As requested, I attach the latest drainage maintenance plan addressing the risks identified by Laura.

Thank you for providing the details, I have the following comments:

Subject: RE: LU/330/18/PPL – Land at Cornfield Close, Littlehampton

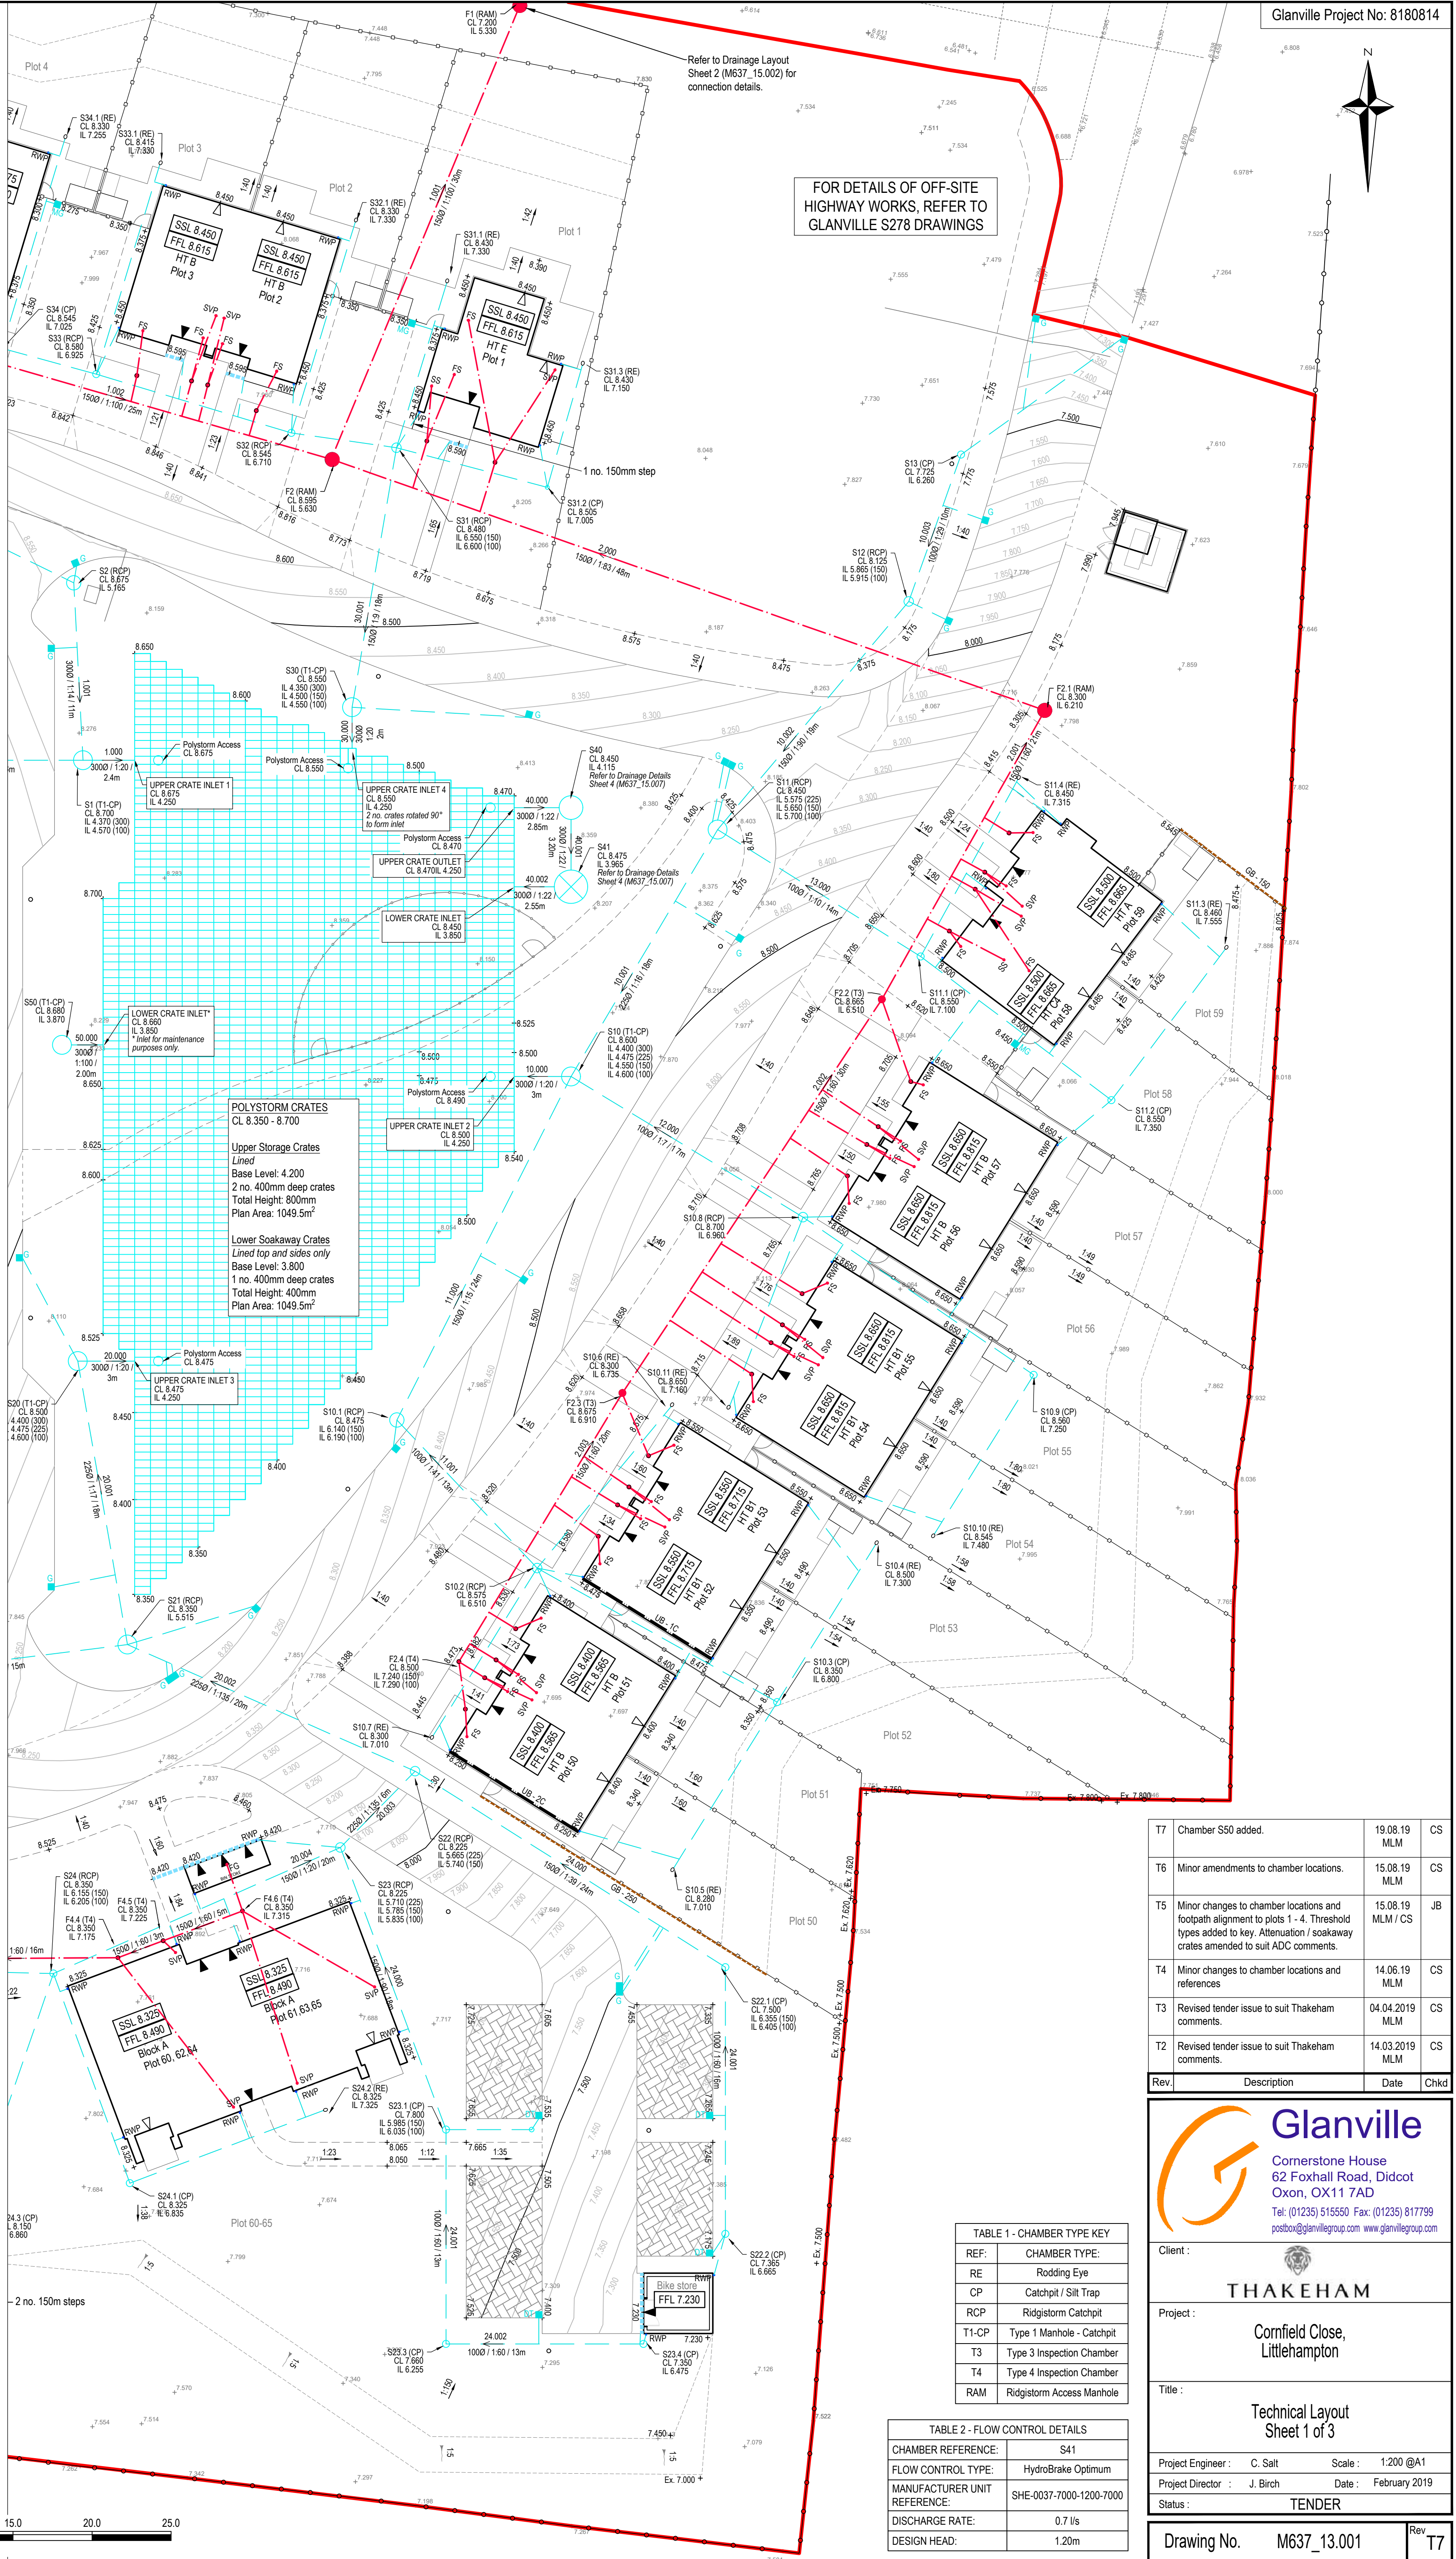
1. Please provide a manhole schedule printout from MicroDrainage to facilitate my review.
This has now been added to the calculation results pdf, with the manhole references matching the references shown on the Technical Layout. *There are a few discrepancies between plan and calculations, however these are minor and do not impact upon the overall results.*
2. Invert level of inlets to upper crate are inconsistent between plan and calculations.
These have been adjusted to match, and revised calculation results attached. *Okay.*
3. Please provide half drain time calculations in a format that can be reviewed by myself.
Please find attached hand calculation. *Okay, point closed.*
4. Are you satisfied that the construction details for pipe bedding and surround and manholes etc. are sufficient given the potential for differential settlement?

I understand that the hydrobrake needs to be located downstream of the storage crates. What I am struggling to understand is why such depth (in excess of 3m) is required given that the site is not that extensive. Could you please provide a revised technical layout drawing, showing falls of pipes etc.

To clarify with regards to the network design, given that the site is built on landfill, pipe gradients have been steepened from standard minimum gradients in order to safeguard against the potential effects of differential settlement (e.g. 100dia. to 1:60, 150dia. to 1:90, 225dia. to 1:135, and 300dia. to 1:180). A similar exercise has been undertaken on the foul design, which is also constrained by the invert level of the outfall point, and as such the surface water network has been designed slightly deeper in some locations in order to avoid clashing with the foul network. In addition, the sewer networks have been designed to be located outside of hard paved areas as much as possible, again in order to safeguard against the effects of differential settlement of the manholes and the road (designed with a Tensar system preventing differential settlement), which means that pipe runs are longer than you would usually expect for a site this size. The topography of the site is also a factor, with ground levels highest in the centre of the site and falling towards the boundaries, with root protection areas around the boundaries which must be considered in the proposed levels design. As such, the storage cannot be raised any higher without impacting on the design or performance of the upstream network.

A 4.5m deep manhole is similar to the standard Type 1 manhole (3-6m deep) specified (and therefore considered acceptable) by Sewers for Adoption (7th Edition).

We accept having manholes at this depth is not preferred, however, as noted, the site constraints have dictated the invert levels and requirement for the flow control, and as such it is fixed at this depth. The hazard which arises from having deep manholes will be covered in the Designer's Risk Assessment and in the Health and Safety File.

Drawing No. M637_15.003

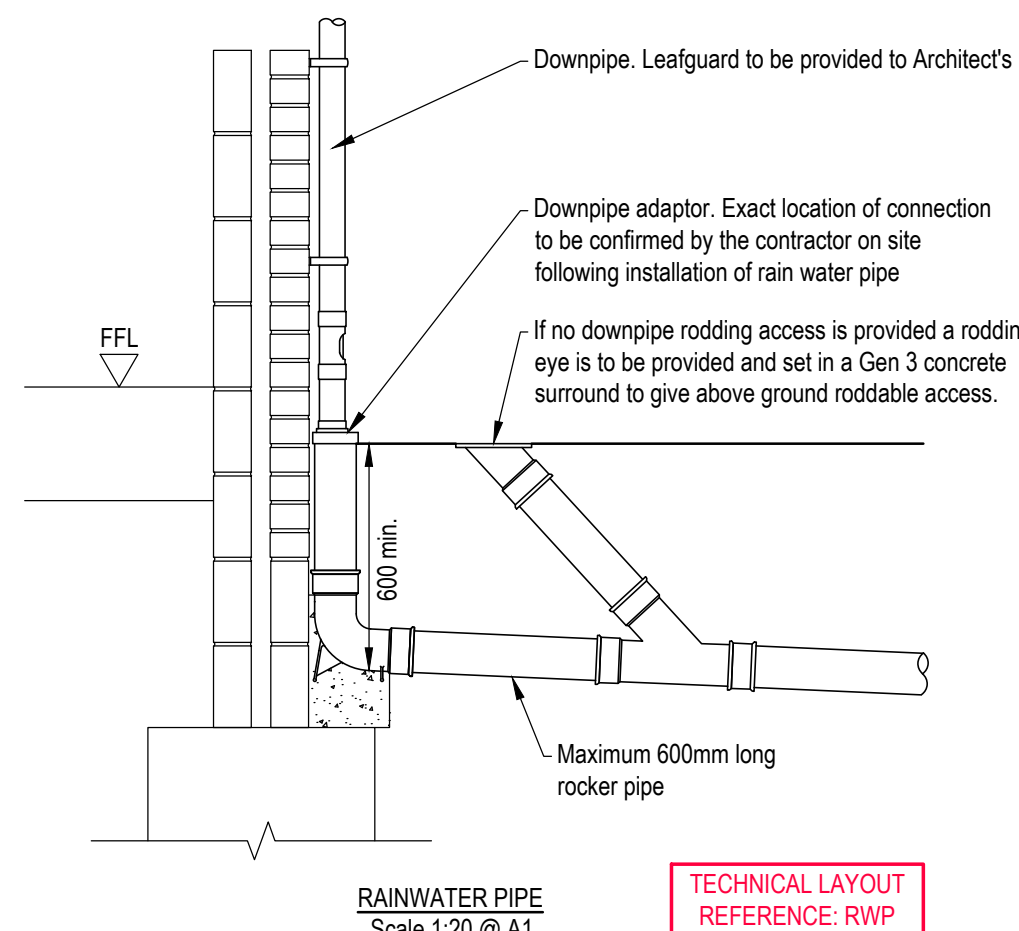
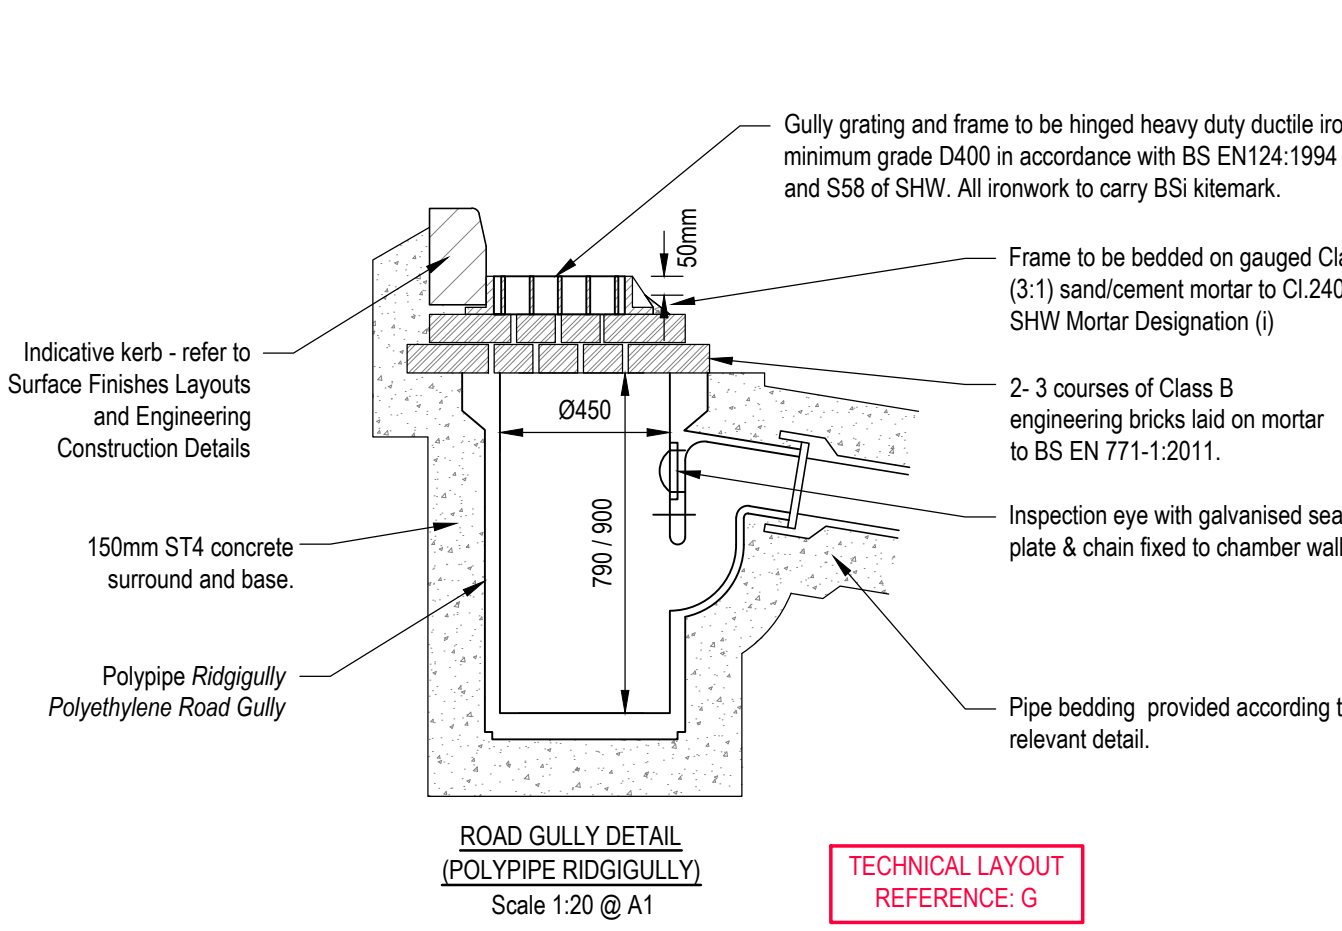
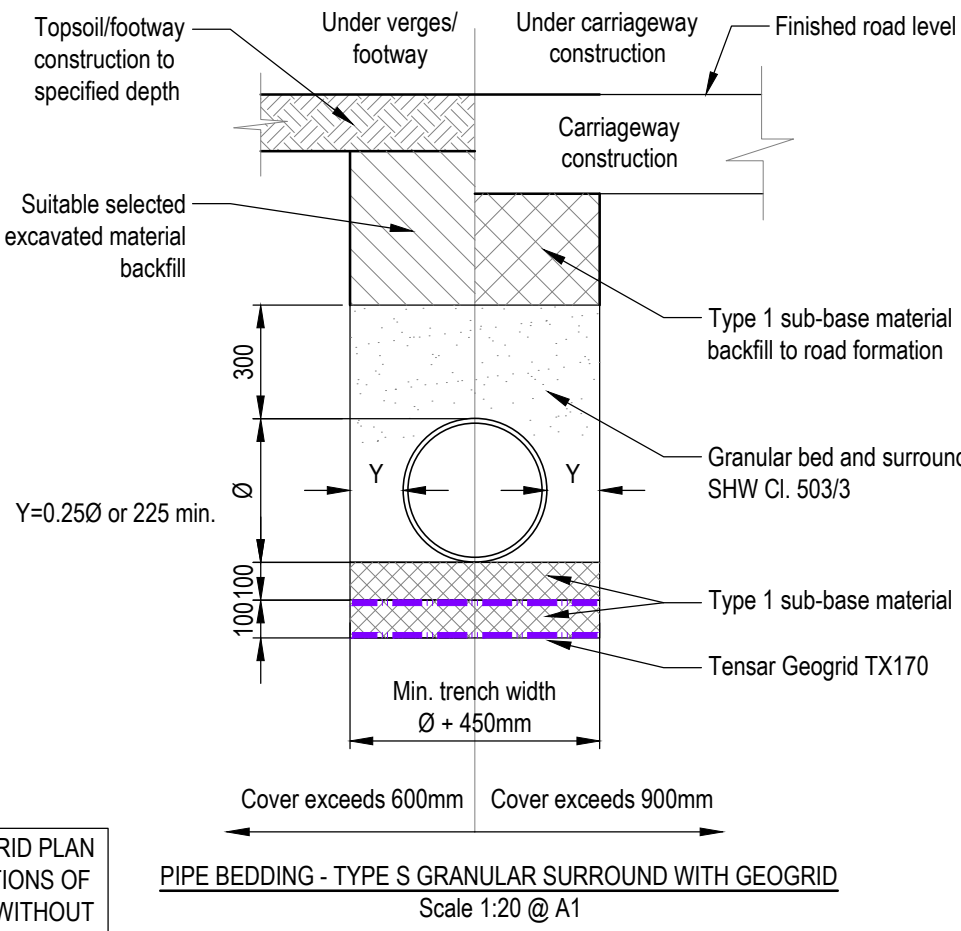
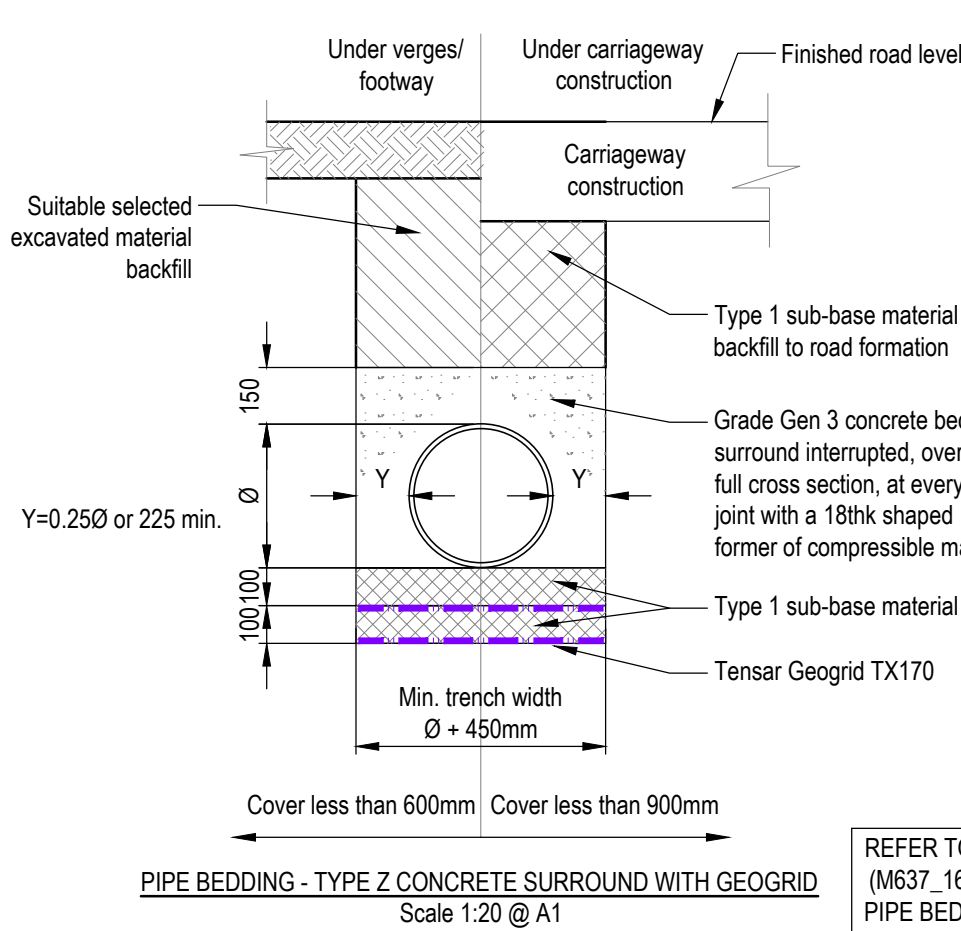
Yes. The construction details with the Tensar Geogrid layers have been developed with Tensar and the geo-environmental consultant (GESL) and we are satisfied that this is a suitable design for the site conditions. As previously mentioned, minimum pipe gradients have also been increased in order to mitigate the risk of differential settlement. Drawing M637/16.002 shows the Geogrid installed within the trench below the drainage, but drawing M637_15.003 shows details of cutting and reinstating the Geogrid, which would indicate the majority of the drainage will be below the proposed Tensar geogrid layers? Therefore, not actually supporting the pipework, please confirm.

I have significant concerns even if pipes are located above the Tensar Geogrid; the site is unstable in its nature due to previous land use and the additional disruption of piled foundations and heavy traffic will result in a significant potential for settlement to occur. I would recommend that you refer to BS EN 1610:2015, particularly clause 7.3 Special methods of bedding or support.

Please provide supporting structural design calculations.

To clarify, there are two different uses of the Tensar geogrid: as a pipe bedding stabilisation detail; and as a Mechanically Stabilised Layer (MSL) at the base of the road construction. Drawing 16.002 (Tensar Geogrid Plan) shows both of these uses: where Tensar layers are used in the bedding of the pipes, as per the details on 15.004 (Drainage Details Sheet 1); and where the MSL is used at the base of the road construction. All pipes are located below the MSL, hence why a detail has been provided for reinstatement of the geogrid (should this be required), which is the one you refer to on 15.003 (Engineering Details Sheet 3).

Tensar have provided some comments on this as follows: "This solution has been used on many projects where there is concern that settlement in the pipe work will cause traps and blockages in the drainage runs. In this case the use of a TriAx geogrid within a granular well graded fill will mitigate any differential settlement (it will not stop overall settlement) along the pipe run. This in conjunction with the increased fall of the drainage runs will in my experience be an effective solution."

Other mitigation measures against the risk of pipe settlement have also been used, such as increasing pipe gradients, and using 6m pipe lengths rather than shorter lengths.

In addition, whilst we acknowledge that additional loading on the landfill can promote further settlement, it is also worth noting that the landfill is only 1.5-2.7m deep, is void of significant proportions of organic matter, and was closed several decades ago (studies suggest that 90% of settlement usually occurs in the first 5 years after closure of a landfill). Given this, the statement from Tensar and the mitigation measures outlined above, further settlement affecting pipe performance and integrity is considered to be a very low risk to the future performance of the drainage system. Therefore, we do not consider it necessary to provide structural calculations in order to support the design.
